From: Gregg, Robert <Robert.Gregg@lancashire.gov.uk>
Sent: 16 December 2020 17:02
To: Laura Eastwood
Cc: Planning; LHS Customer Service
Subject: D3.2020.0981 - Land At Moran's Farm Pendleton Road Wiswell Clitheroe BB7 9BZ

In respect to the proposed change of use of land for the siting of four holiday lodges with associated parking, access and amenity areas, I have the following comments to make.

Pendle ATC 1, Pendleton Road

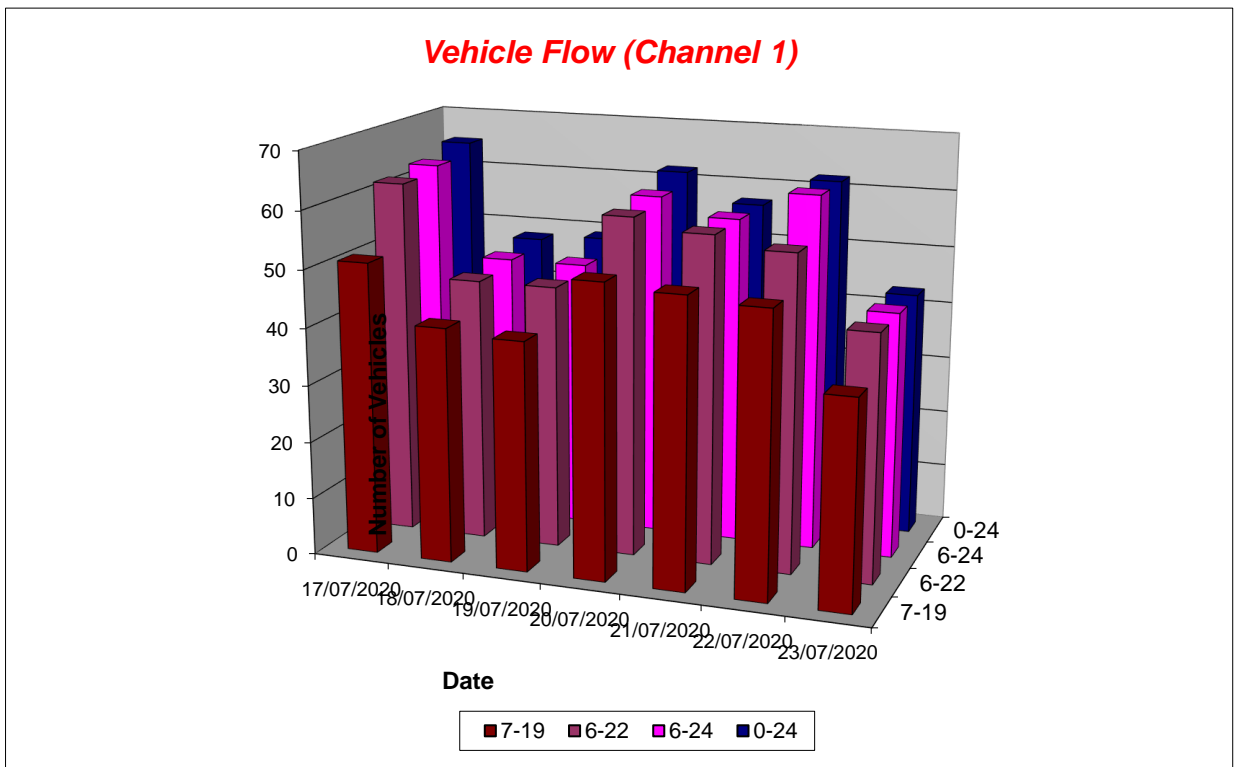
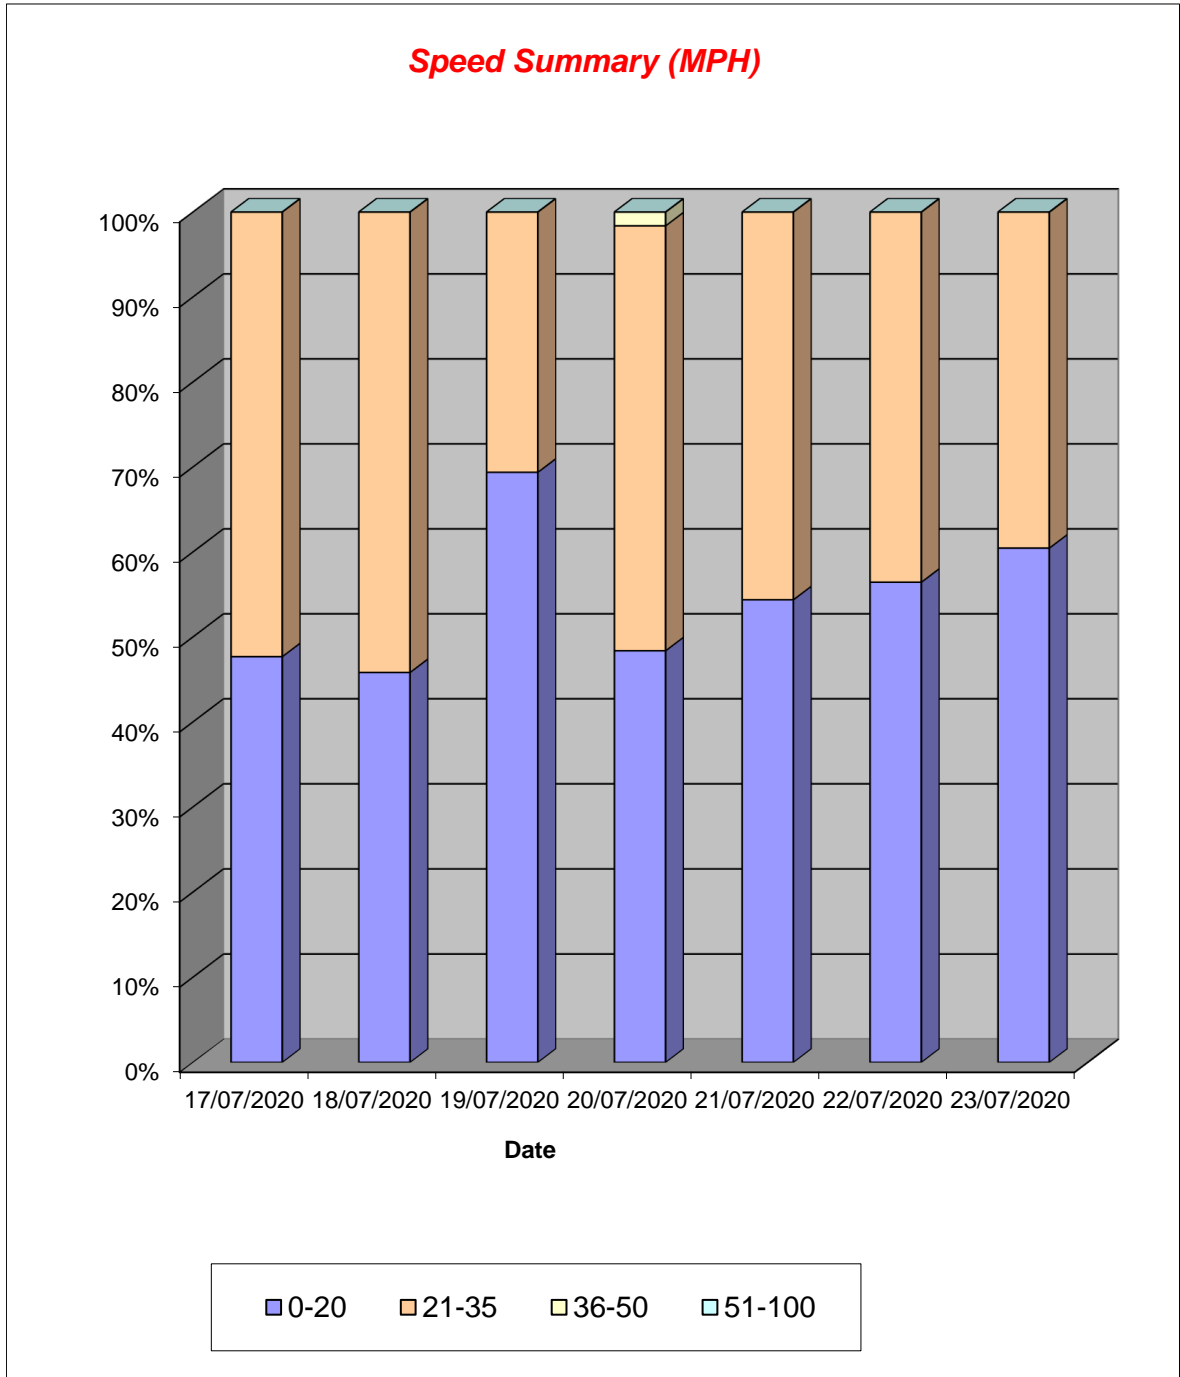
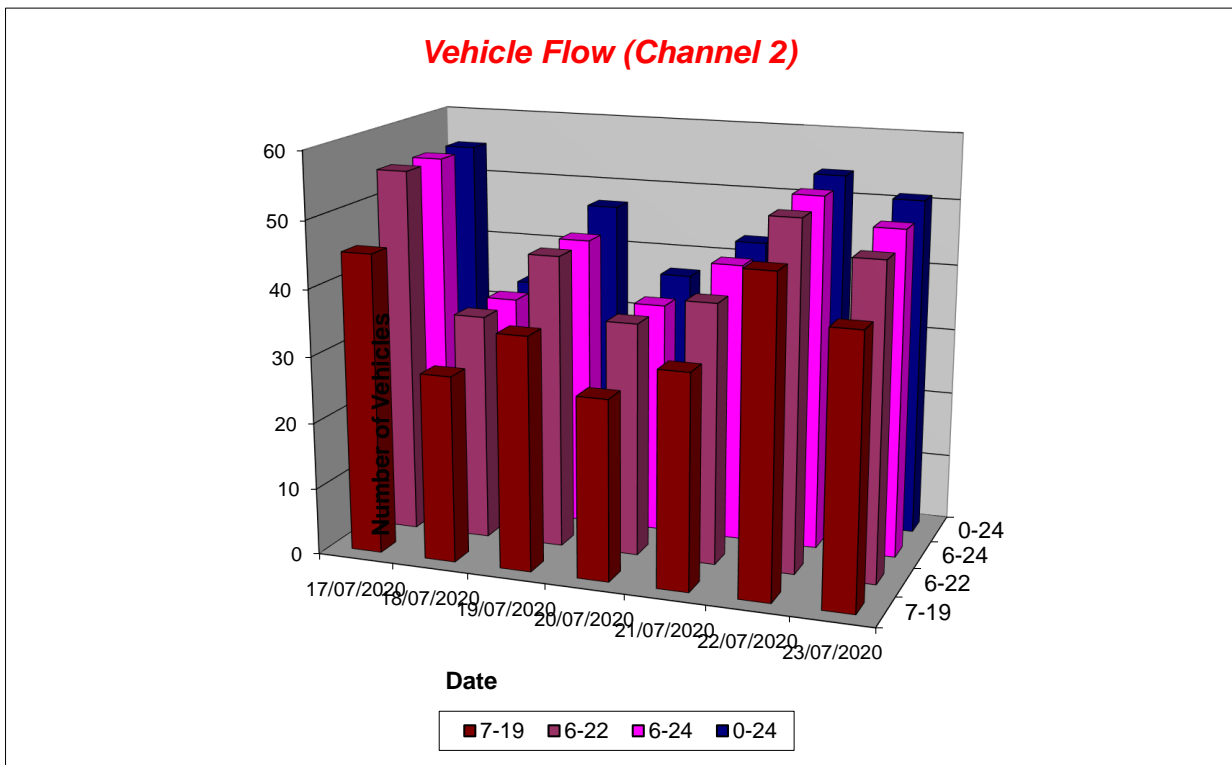
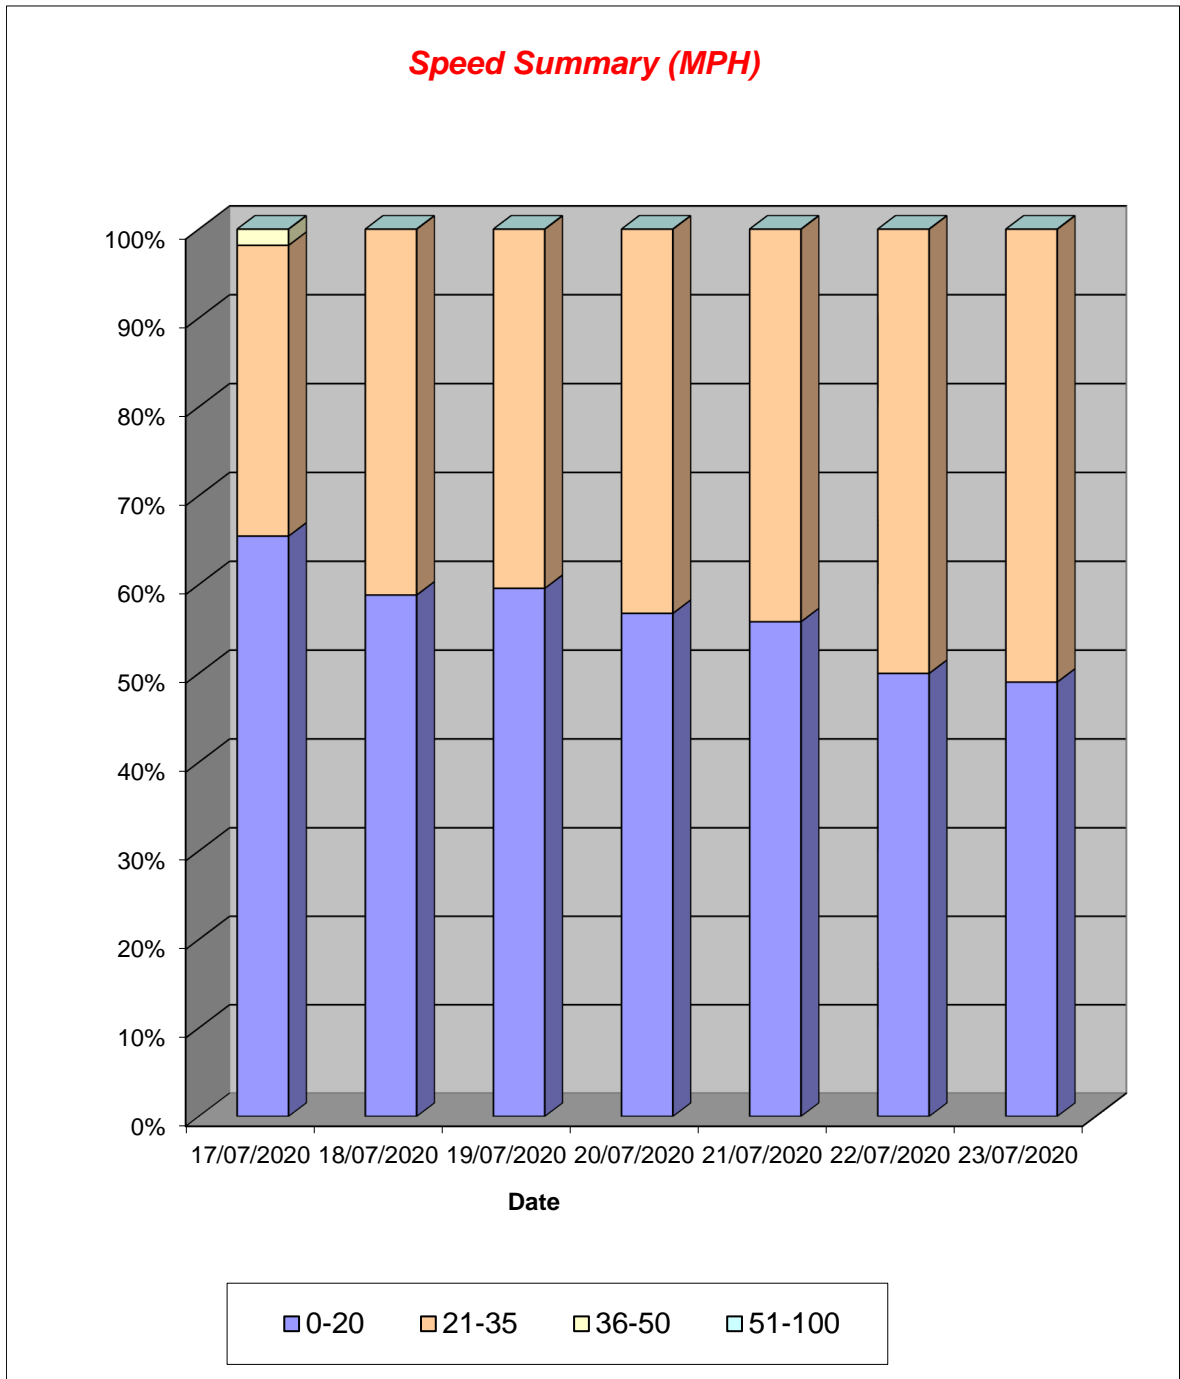
At present with traffic counts remaining lower than historic levels, for the foreseeable future traffic counts would not be accepted by LCC as the local highway authority. However, with that being said and with total disregard to any volumetric data, purely looking at the speed data to determine visibility splays, should a large enough sample of data be submitted than it would be considered as reasonably fair to determine a realistic 85%ile from that data being submitted. The submitted traffic survey that had been undertaken between the 17/07/2020 – 23/07/2020 however would not quantify a large enough sample due to the lower number of vehicles on the road and I ask that more data is provided in order to determine a realistic 85%ile speed along Pendleton Road in proximity of the application site.
